Response to Planning application from Hertfordshire County Council (T and CP GDP Order 2015)

District ref: 6/2020/1211/HOUSE
HCC ref: WH/2320/2020
HCC received: 22 June 2020
Area manager: Alan Story
Case officer: Paul Marshall

NORTHAW PLACE COOPERS LANE POTTERS BAR EN6 4NQ

Formation of new vehicular access following removal of existing close-boarded fence and erection of post and rail boundary fence and hedge with timber gate

Drg. No
747 / SP3A

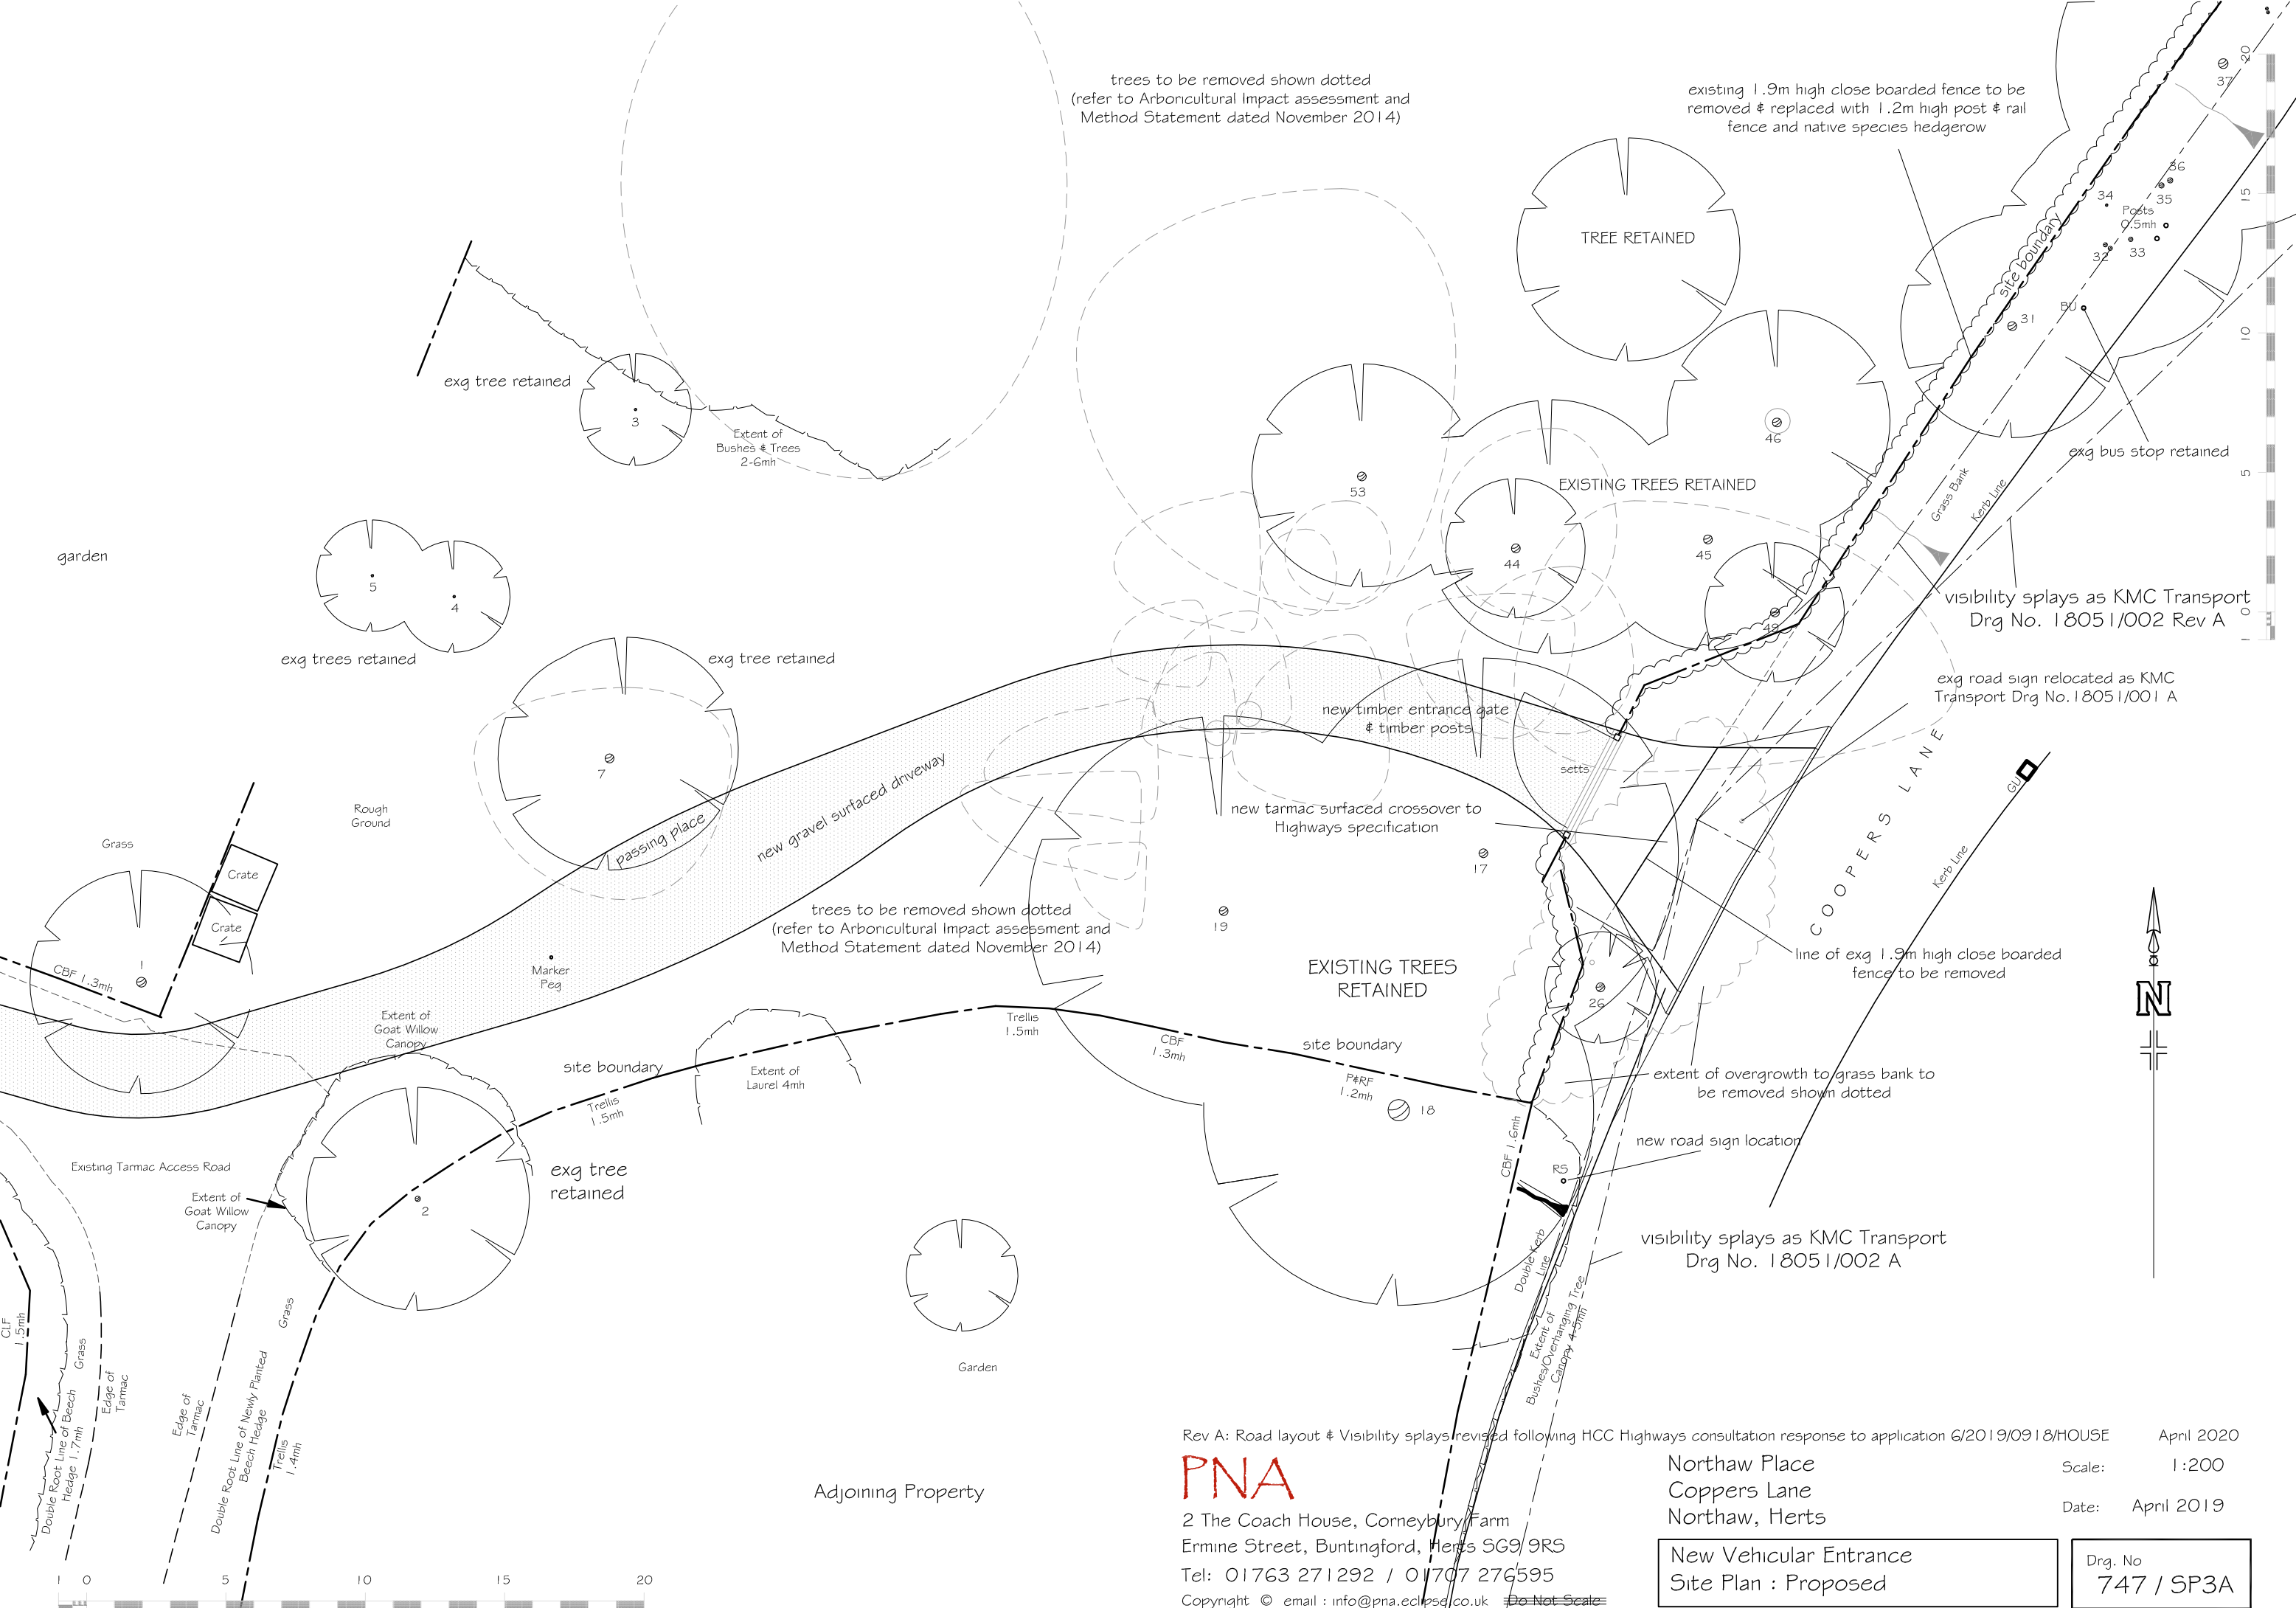
Drawing 747 SP3 A refers to KMC Transport visibility splays on drawing 18051/002/Rev A. This document does not appear to be included in the suite of drawings. The Highway Authority would need to review this drawing to be able to reach a recommendation, therefore the Highway Authority is unable to extend the grant of planning permission at this time
